1-3 Sudborough Road Slipton

Further to my report of 18th October 2018 on the initial clearance and support work for the property following the fire I would confirm that I have re-inspected specifically to comment on the amount of masonry to be rebuilt on the rear elevation. An extract showing this area is copied below.

Based on your proposed scheme shown on drawing 1341-02-11 and also on the demolition drawing 1341-02-10 then the amount of the existing masonry that can be retained can be increased as shown on the diagram below. The red hatch shows the areas to be rebuilt which includes that already removed and then the grey shaded section is the area previously shown as being taken down but we recommend can remain. It is appreciated that for the scheme to be viable that the first floor when rebuilt, should be 450mm wide so as to provide room for the bathroom and this is acceptable from a structural point of view. As the inner skin of the wall will now partly off the hearting then this also means that it is important for this to be grouted.

B REAR ELEVATION
WEST FACING Scale 1:100

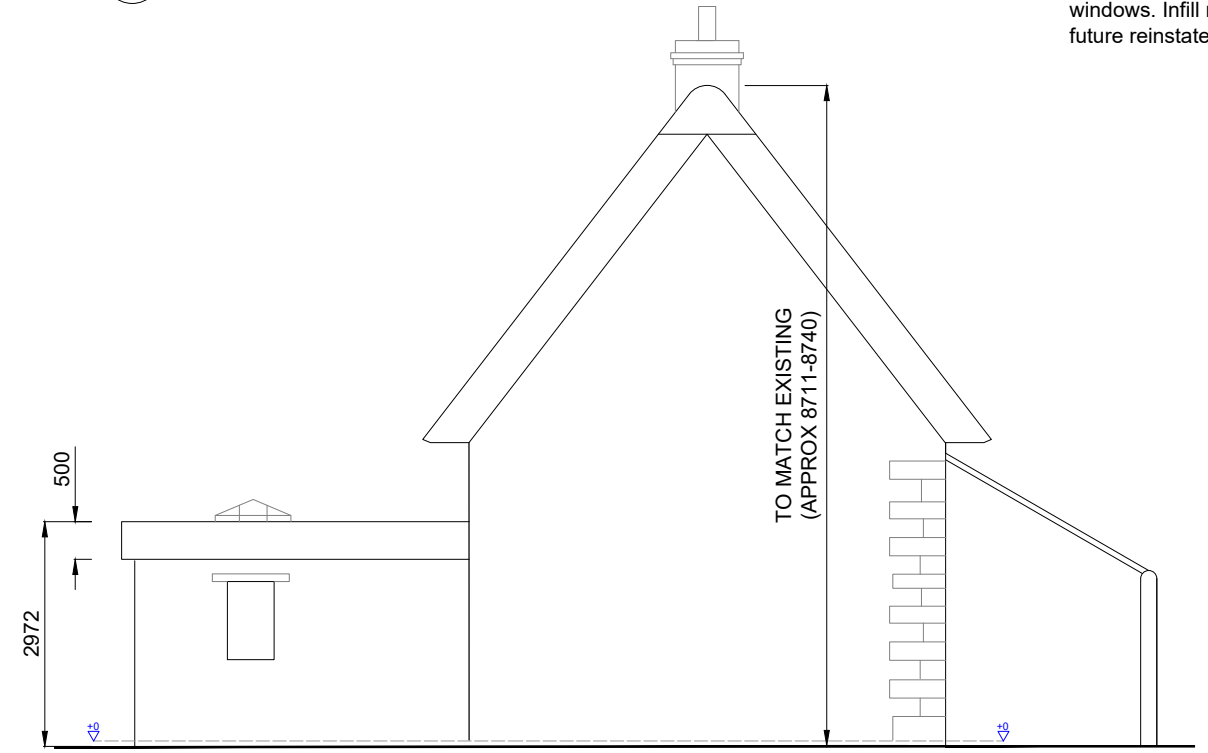
Now the debris has been removed the wall could be inspected in detail and it is evident that from the current line where it has been taken down that this should include an additional 1m which takes it past the external buttress as can be seen on photograph No.1. The masonry on this section, apart from being significantly out of true is in a poor condition as noted when viewing the end exposed section as can be identified on photograph No.2.

On the section of wall to the rear right hand side which is within the extension then there is an outward lean on the wall. A plumbob reading was taken and this is 150mm whereas the wall at the base is some 800mm thick and therefore the centre of gravity of the wall still falls within the base and is considered structurally acceptable. It is important that the wall is a homogenous structure and therefore it is recommended that it is grouted using a lime-based grout. The wall should then be tied to the new floor and also the roof which should be designed so that it does not exert thrust on the wall head.
